Application for a Non-Material Amendment Following a Grant of Planning Permission

Land adjacent to Plough Lane, Leavenheath, CO6 4PH

Erection of 2no. detached dwellings

DC/22/00821

Number:	Rev:
384-101	A

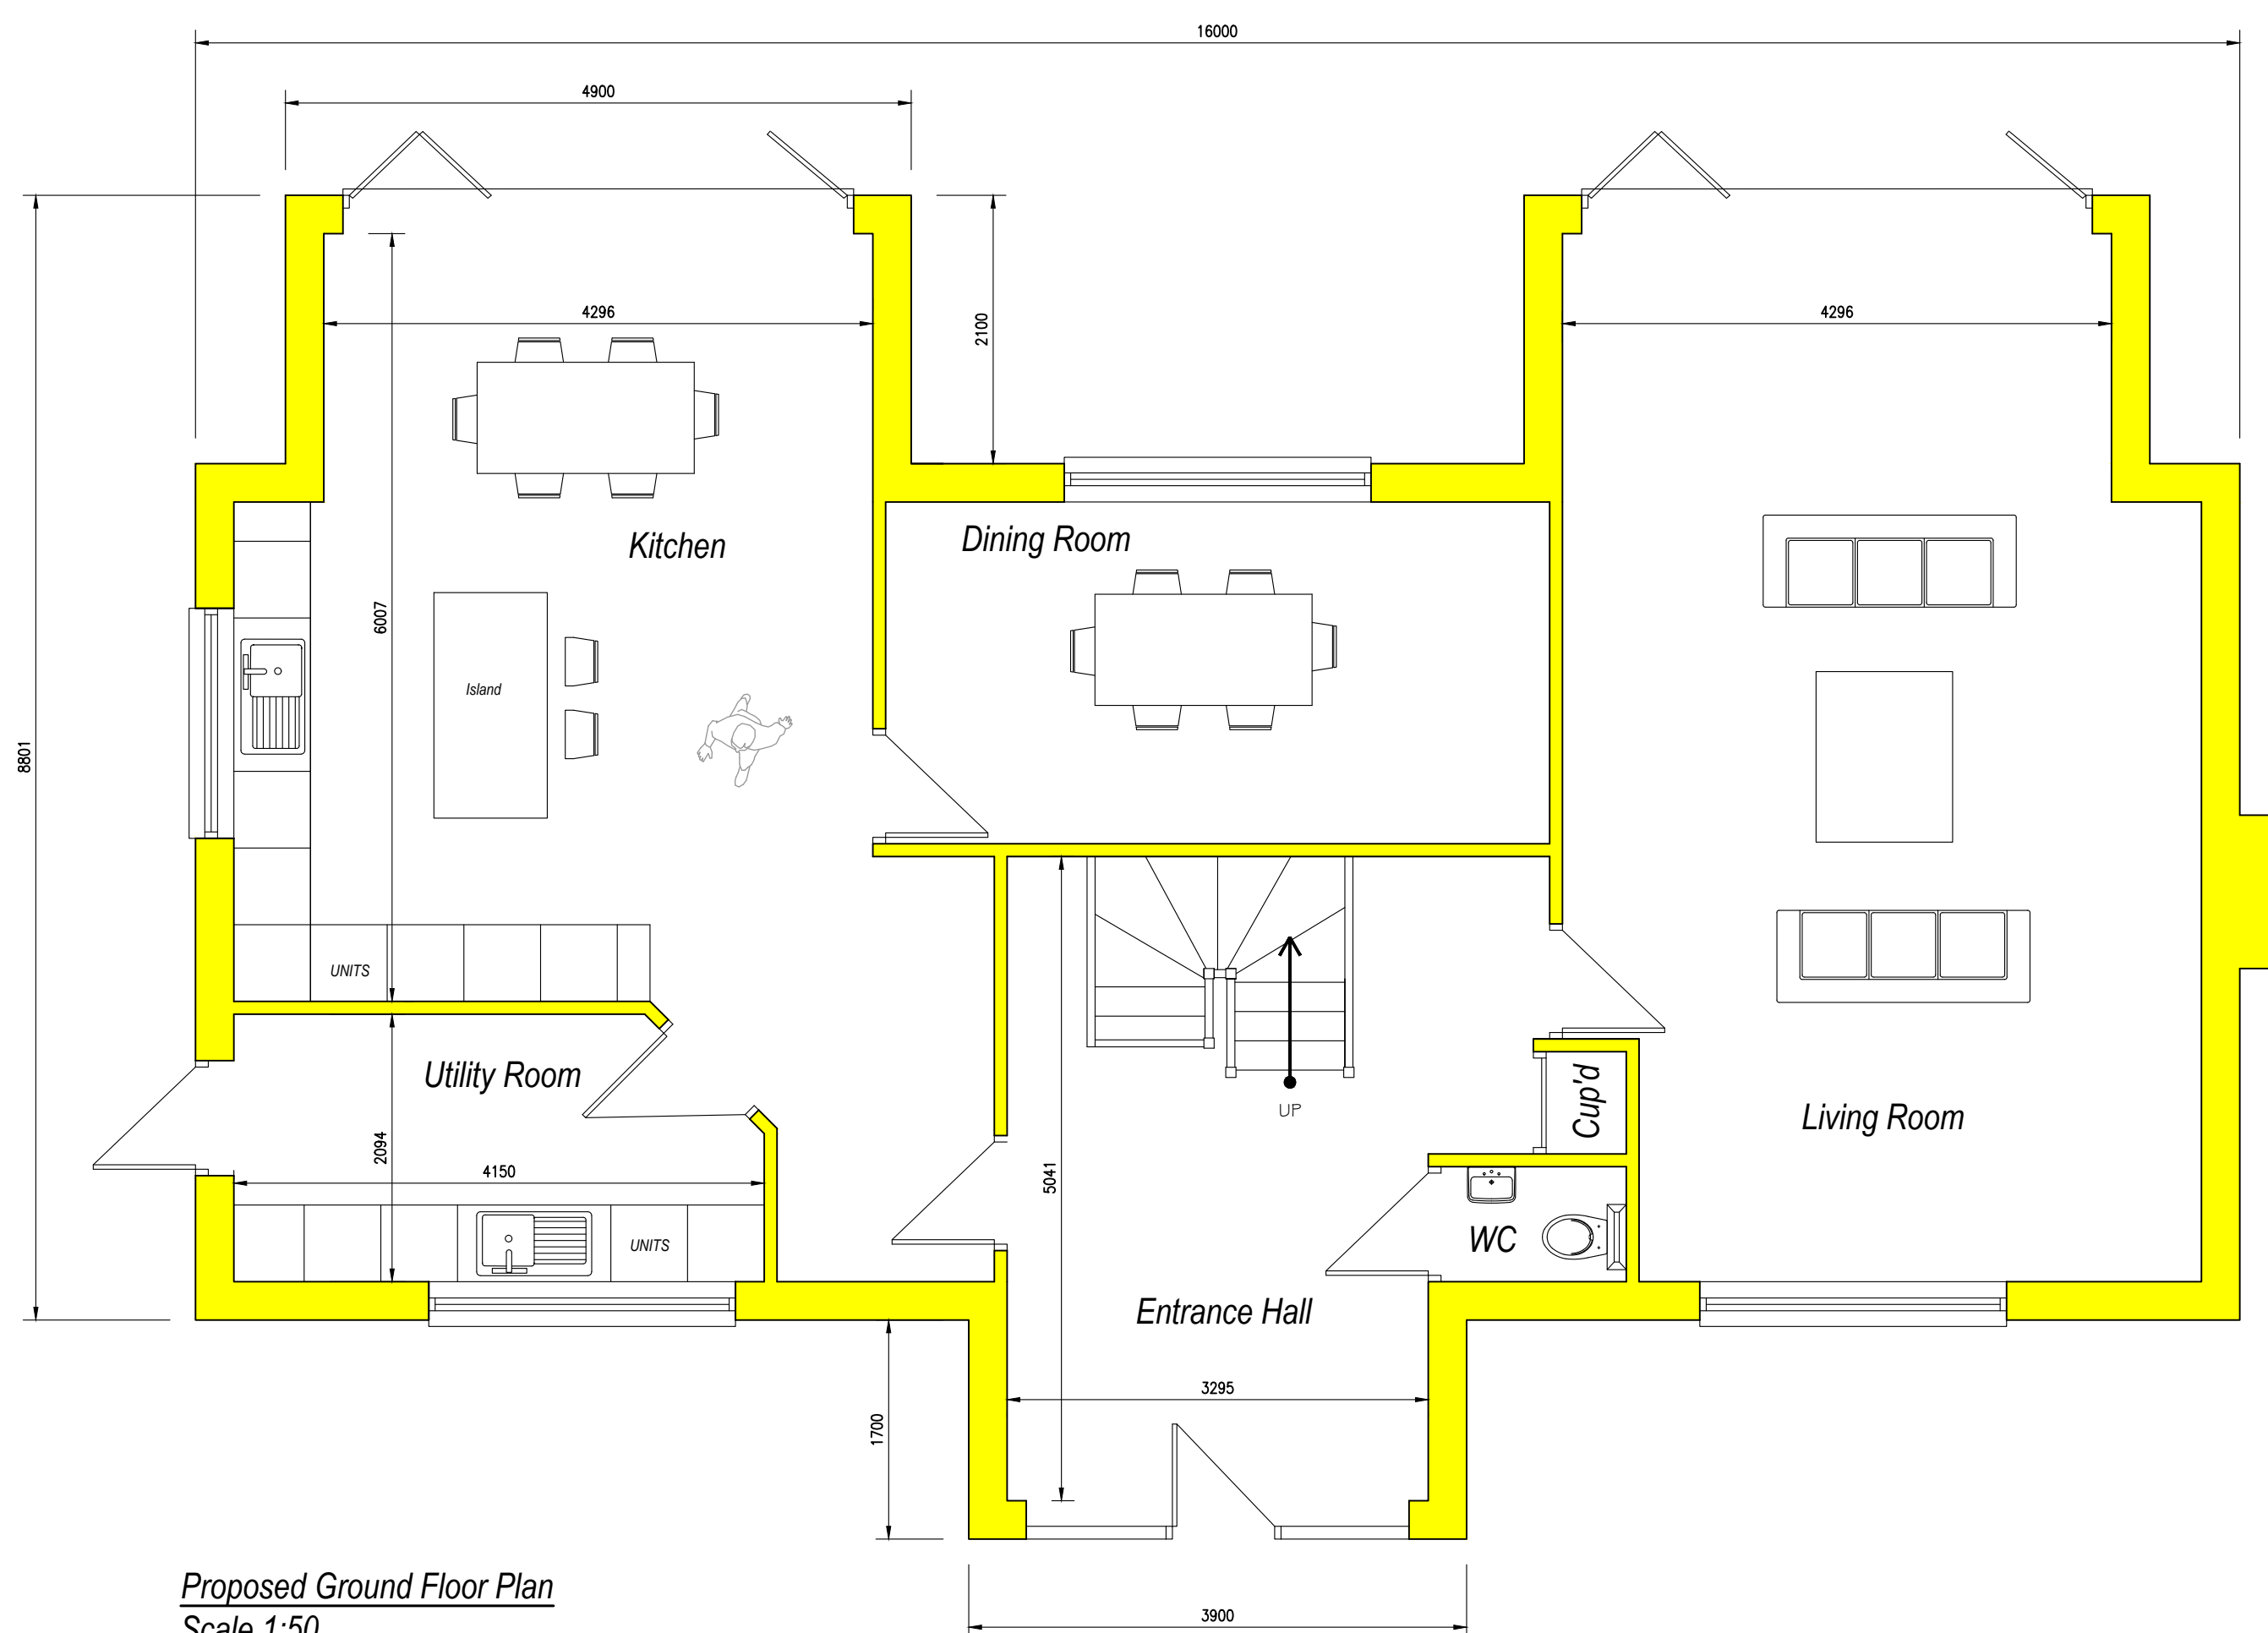
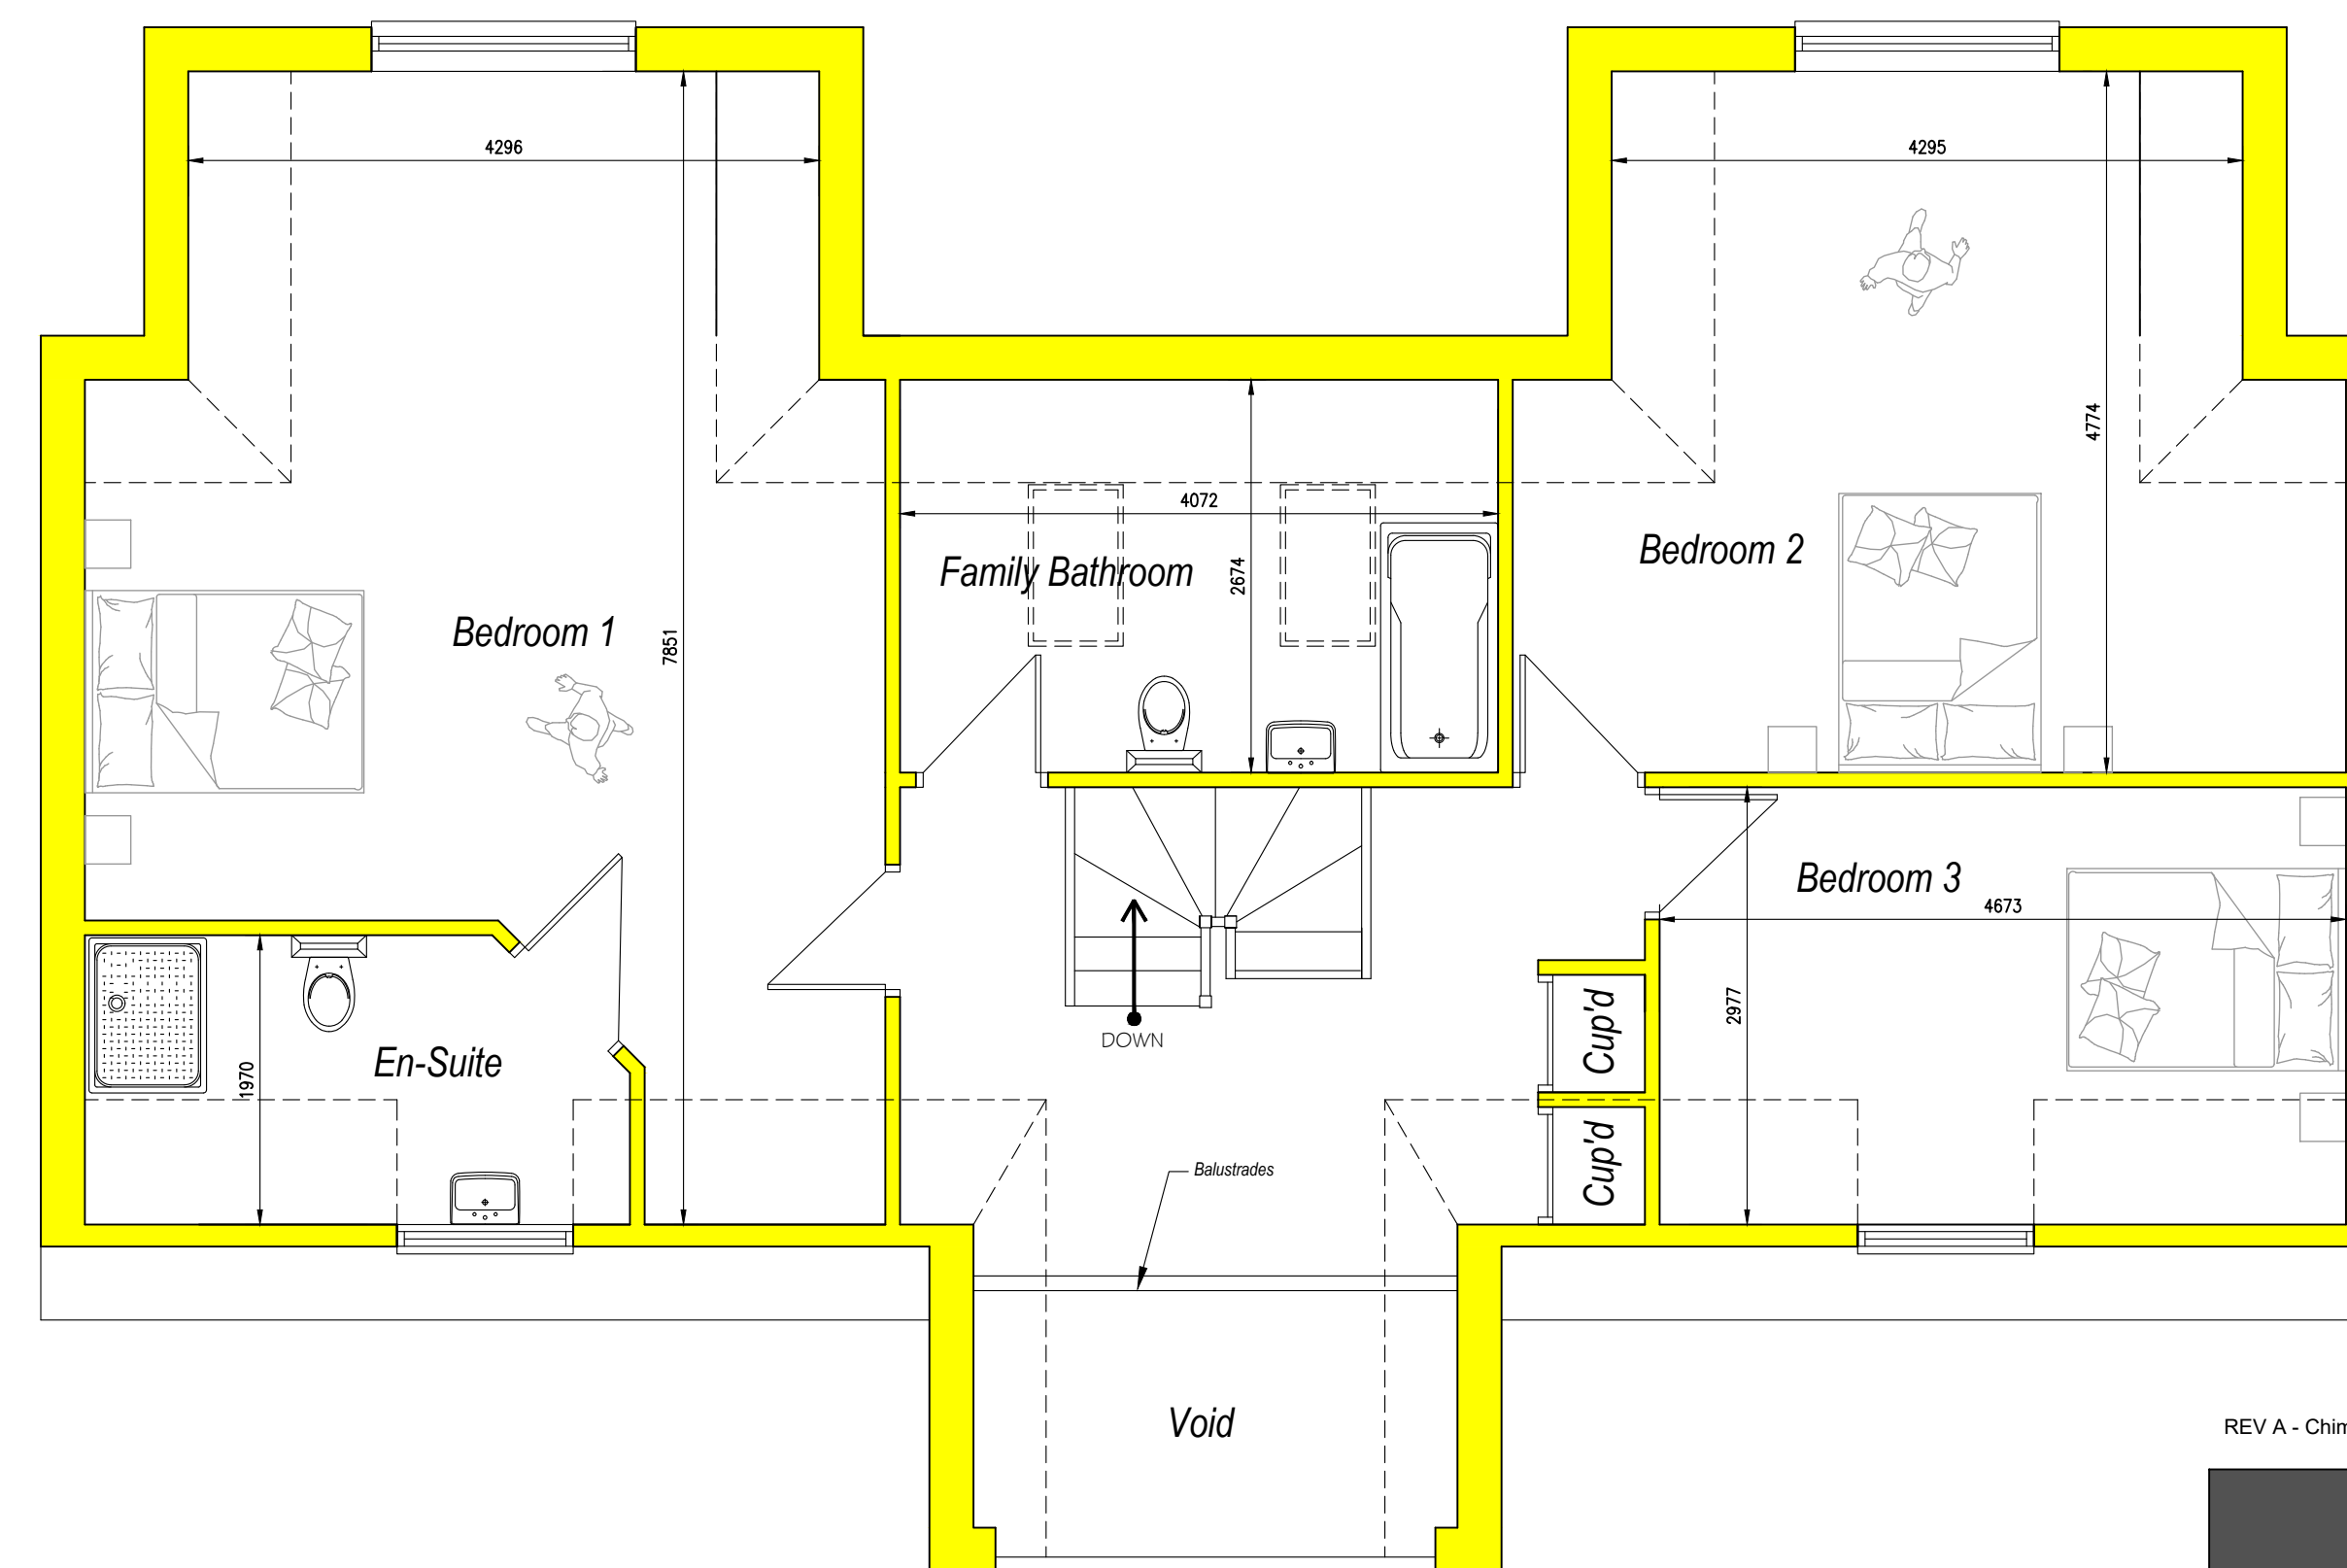
Relocation of dwellings as shown on drawing 384-103B swapped position
Chimney relocated on dwelling A
Single garages changed to double garages for each dwelling
